## DEPARTMENT OF PUBLIC WORKS

### MEMORANDUM

TO: Jeff Watson, Community Development Services  
FROM: Christina Wollman, Planner II *CW*  
DATE: March 21, 2012  
SUBJECT: Mellergaard SG-12-00001

SEGREGATION SURVEY
 PREPARED FOR
 L. BRIAN MELLERGAARD
 A PORTION OF SECTIONS 3, 9 & 10
 TOWNSHIP 17 N., RANGE 18 E., W.M.

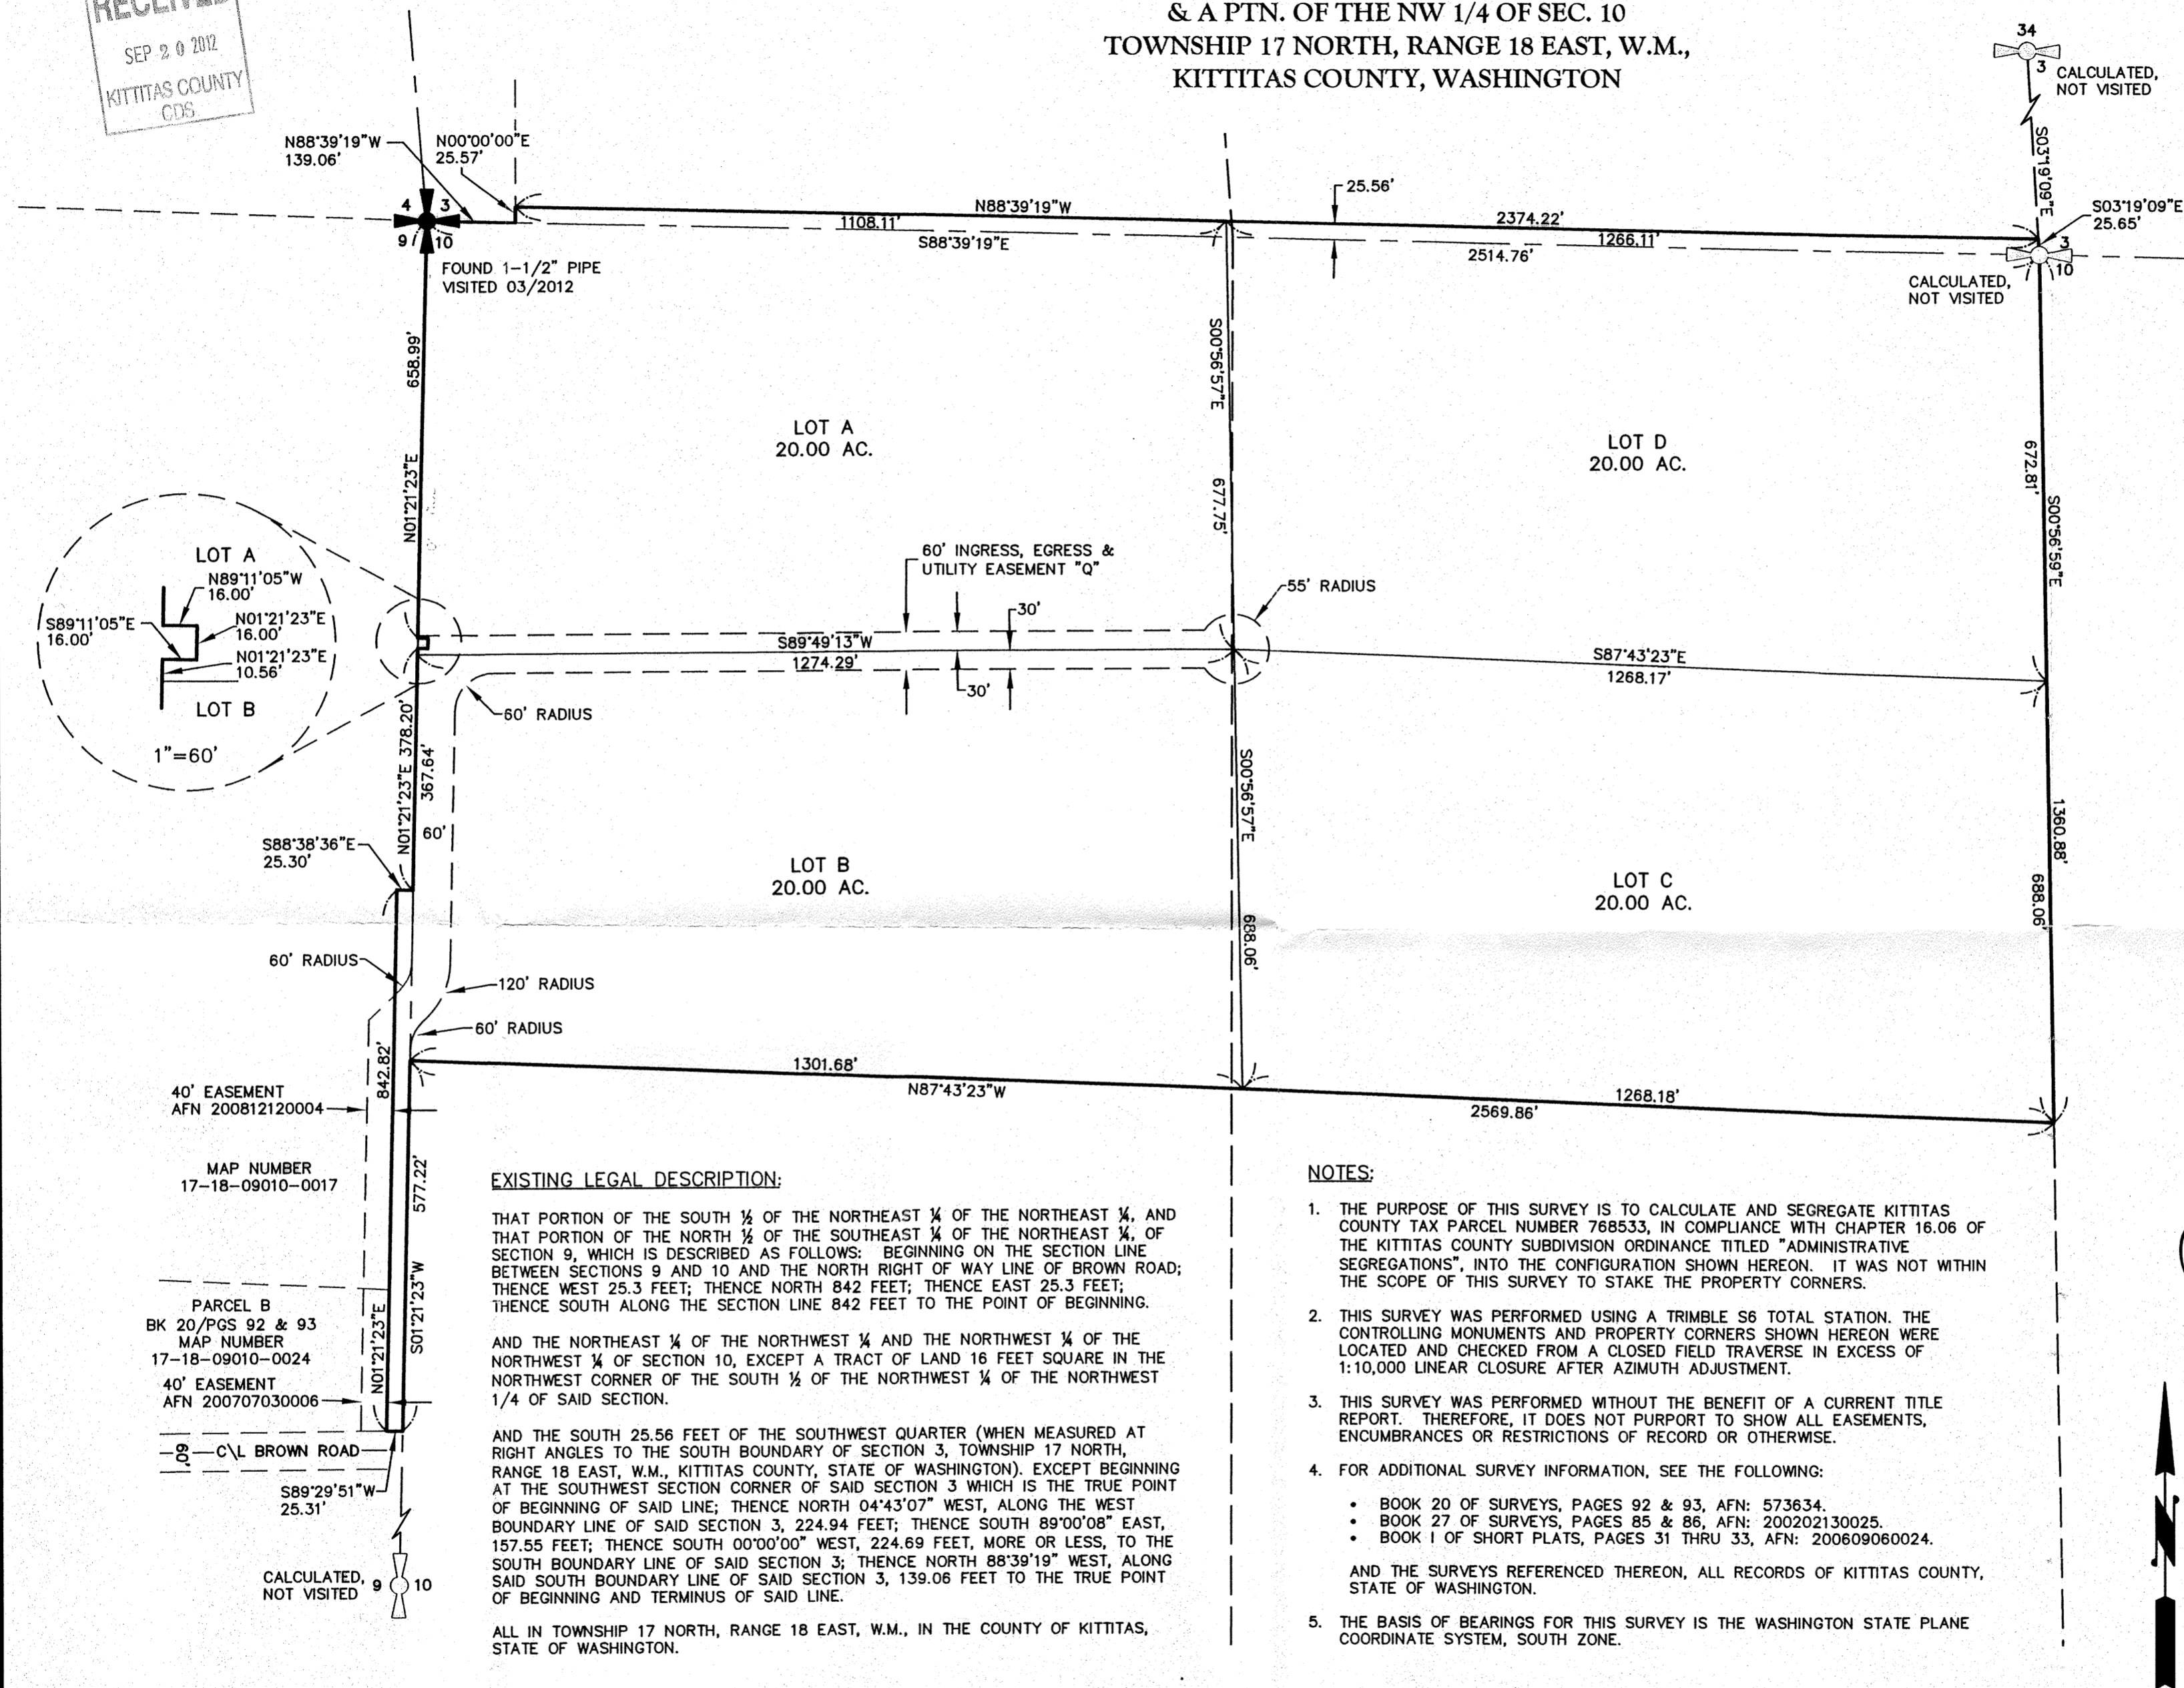
1. The proposed access with appropriate easement(s) shall be shown and shall conform to applicable Kittitas County Road Standards.
2. A survey that describes the final configuration of the subject property shall be required.
